# CITY OF ALBUQUERQUE

October 18, 2017

**Re: Floor and Decor  
Erosion and Sediment Control Plan  
Engineer's Stamp Date 10-17-17 (F17E032)**

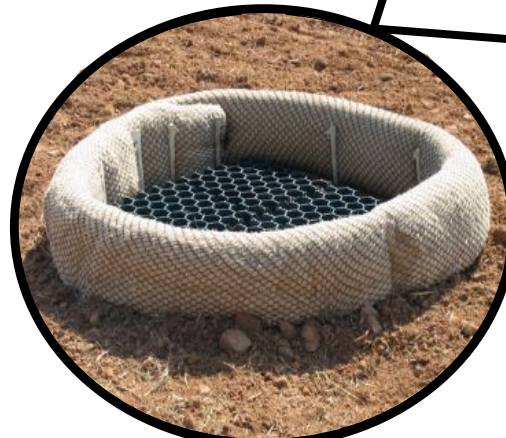
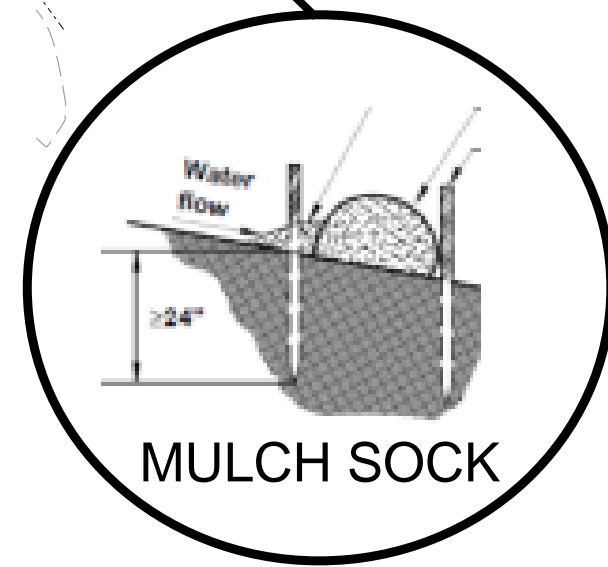
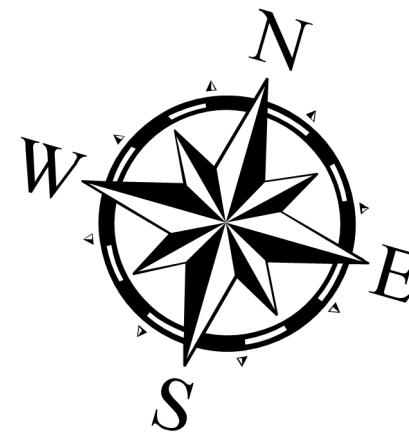
1. It appears that grading is proposed to the back of curb on McLeod Rd. If this is the case, the silt fence will need to be installed at the back of curb.
